Application for a Non-Material Amendment Following a Grant of Planning Permission

Coniston Gardens

Erection of a part single storey, part two storey side extension, and a single storey rear extension

18293/APP/2025/1184

PROPOSED ELEVATION D

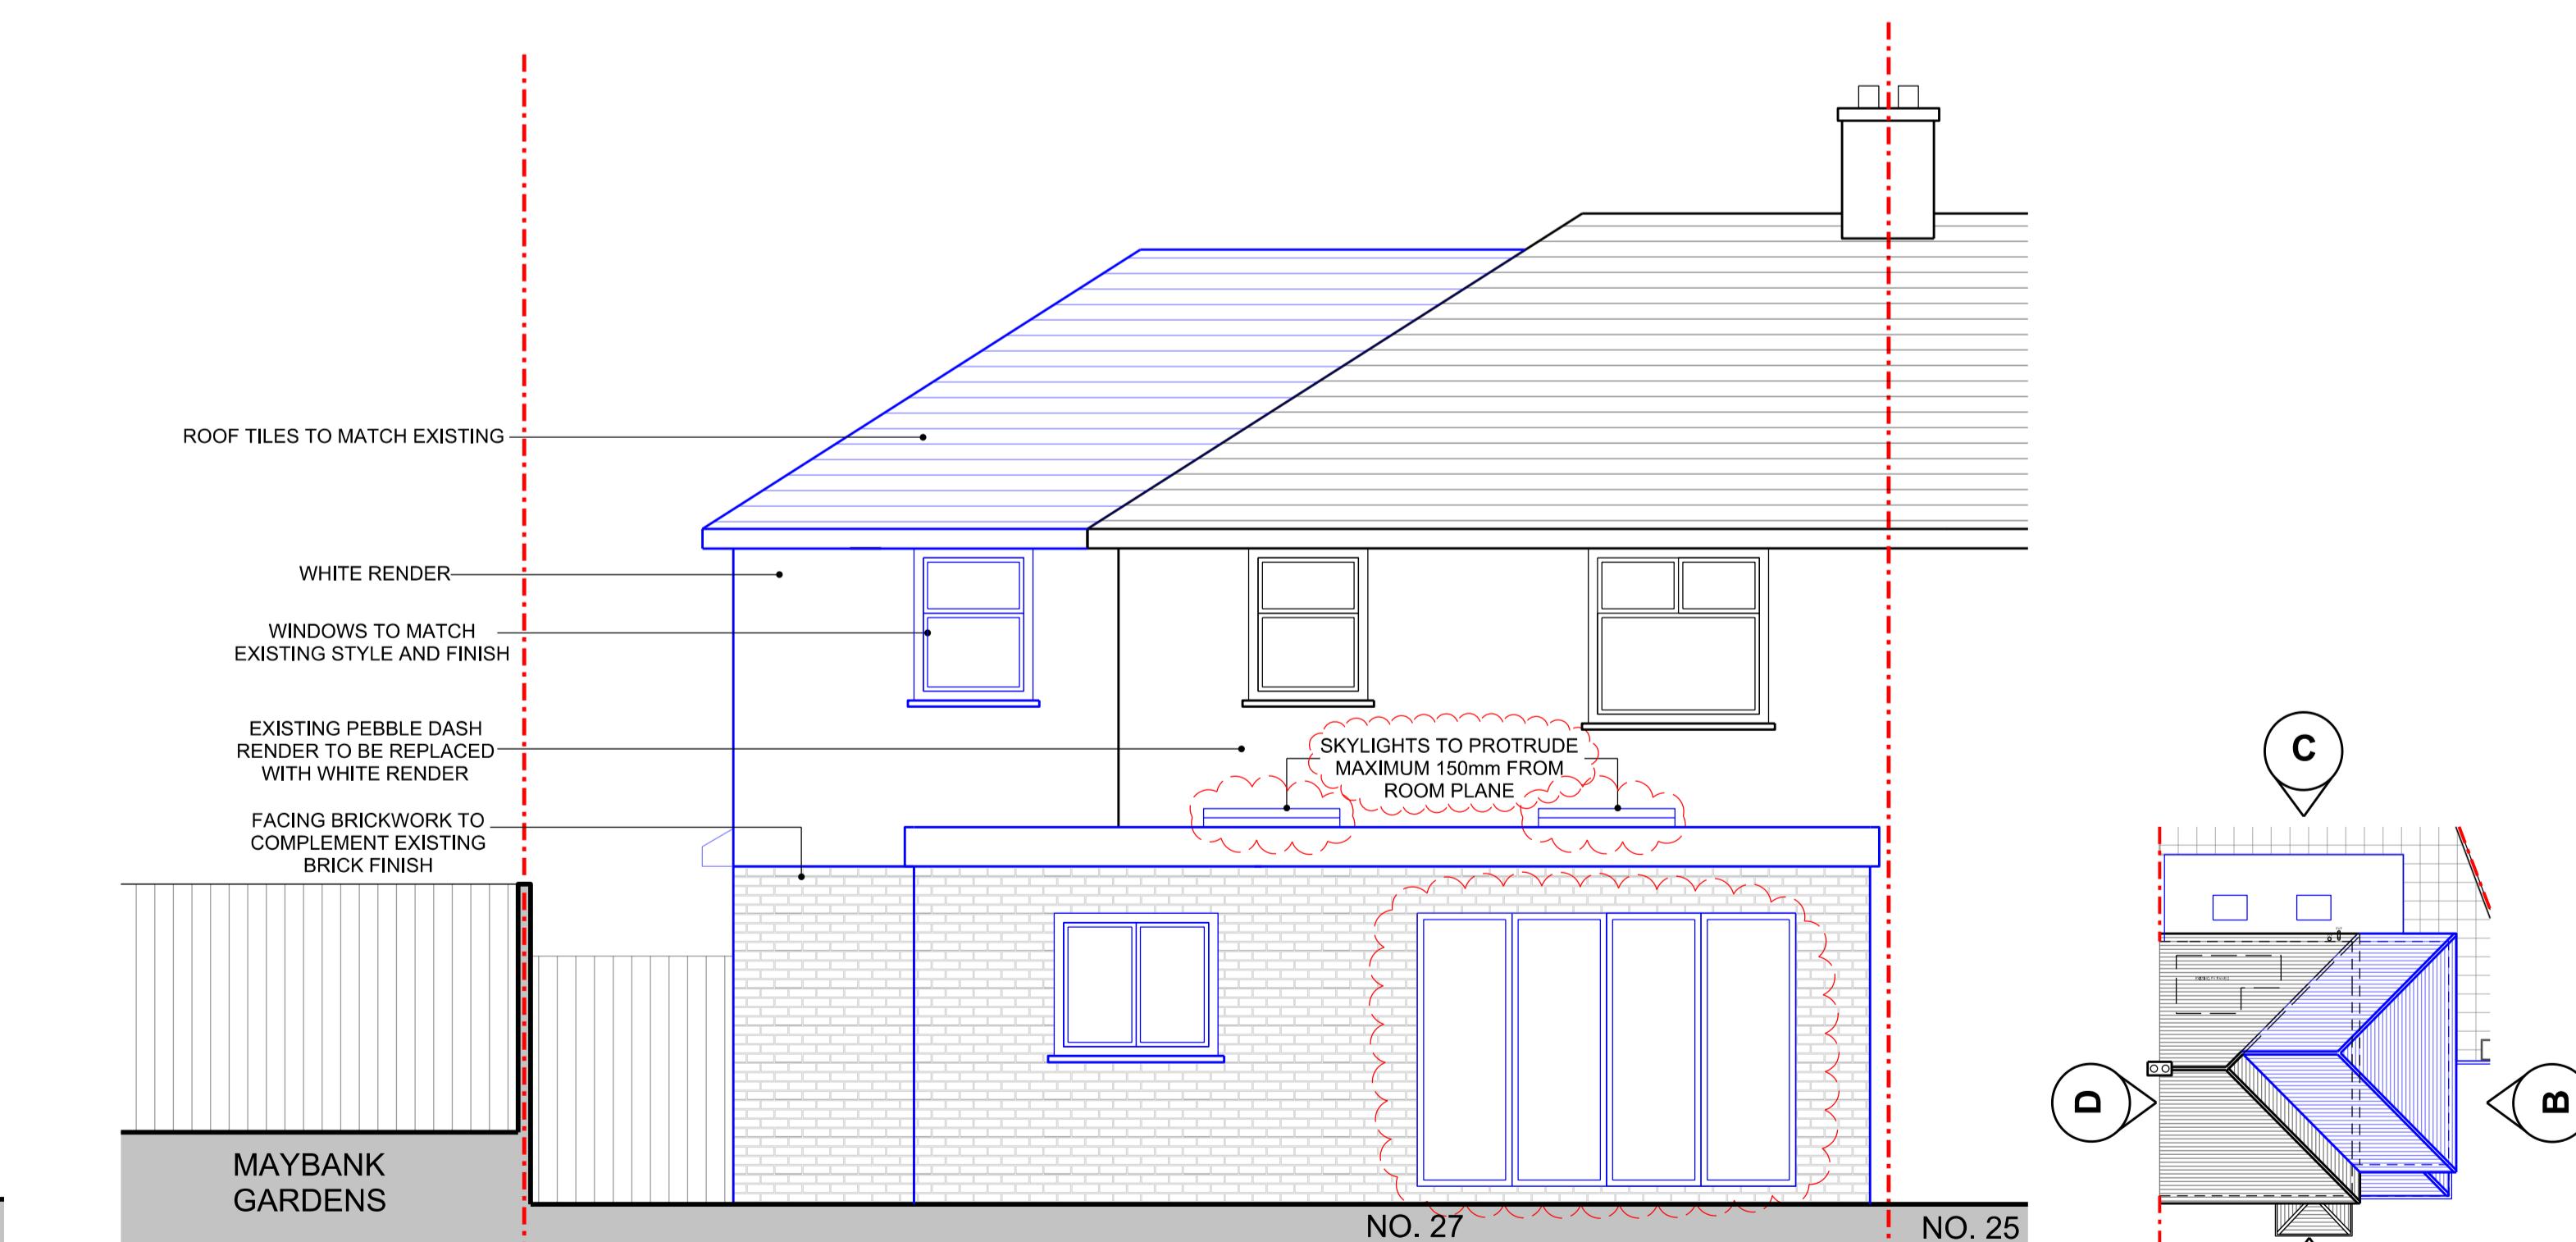
Increased width to approved ground floor bifold door to rear elevation
Increased width to approved ground floor window to side elevation
Proposed new single window to first floor side elevation
Proposed 2no. roof lights to ground floor single storey rear extension. Roof lights to protrude maximum 150mm from roof plane

To help increase daylight entering internal space and provide flexibility in internal furniture arrangement
